CITY OF ALBUQUE

Re: Kiddie Academy Westside – 4590 Paradise Blvd. Mulberry SE
Erosion and Sediment Control Plan
Engineer's Stamp Date: Missing (C12E004)

KIDDIE ACADEMY WEST SIDE
GRADING PLAN

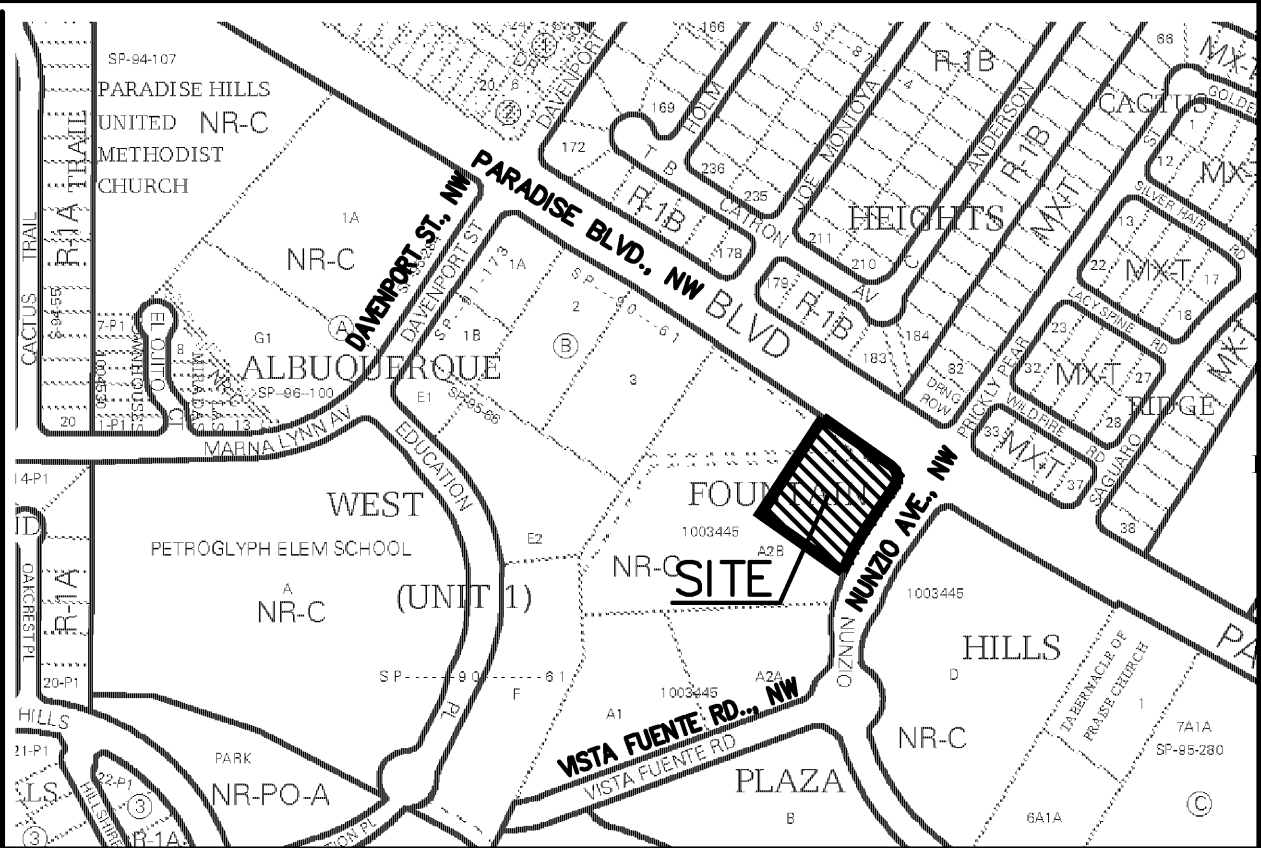
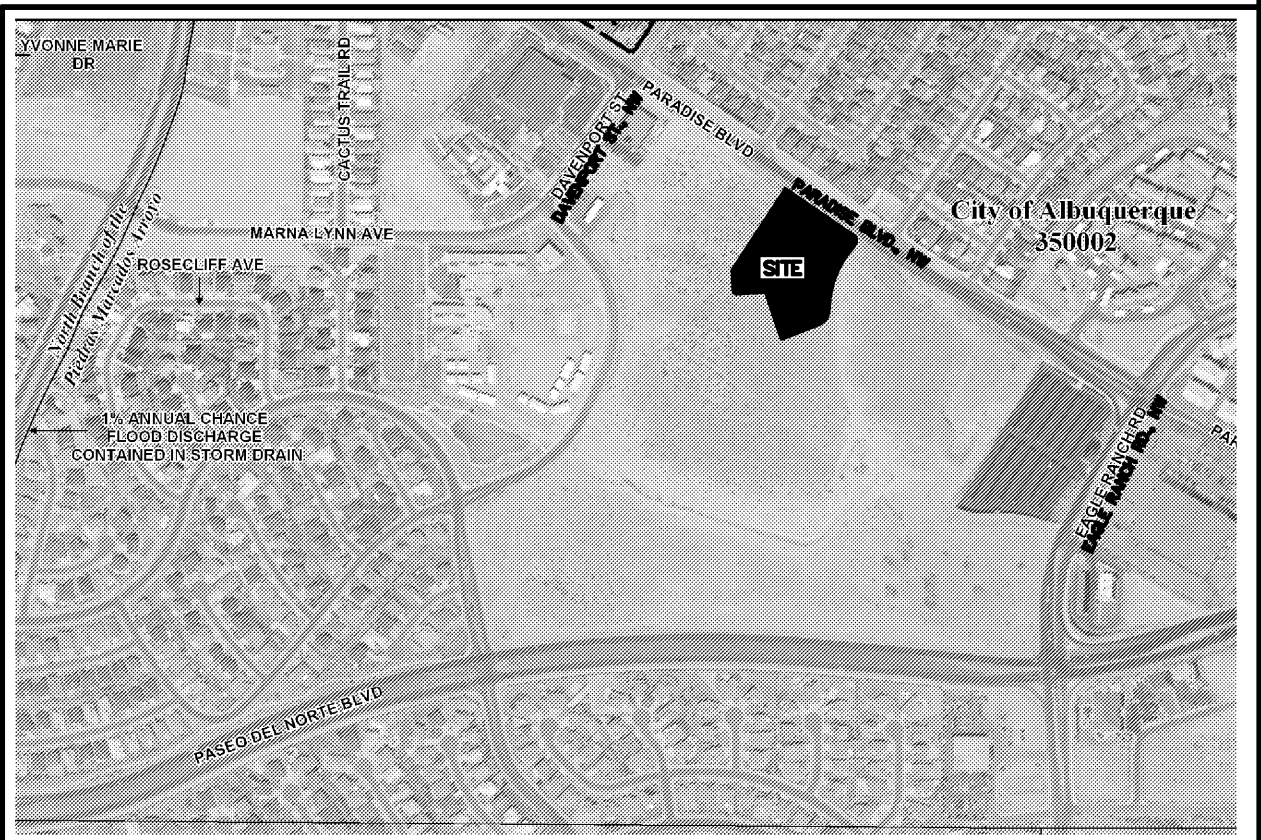
1. The ESC plan must agree with the approved G&D Plan (attached).
2. Add stamp and signature of a PE or CPESC.
3. Show limits of disturbance at the limits of grading.
4. Move silt fence to back of existing Sidewalk.
5. Add temporary sediment traps on the low side of this development. The pond shown on the approved G&D Plan should be identified as a "Temporary Sediment Trap to be the first item of earthwork construction".
6. Please add the following City Standard Notes to the plan.
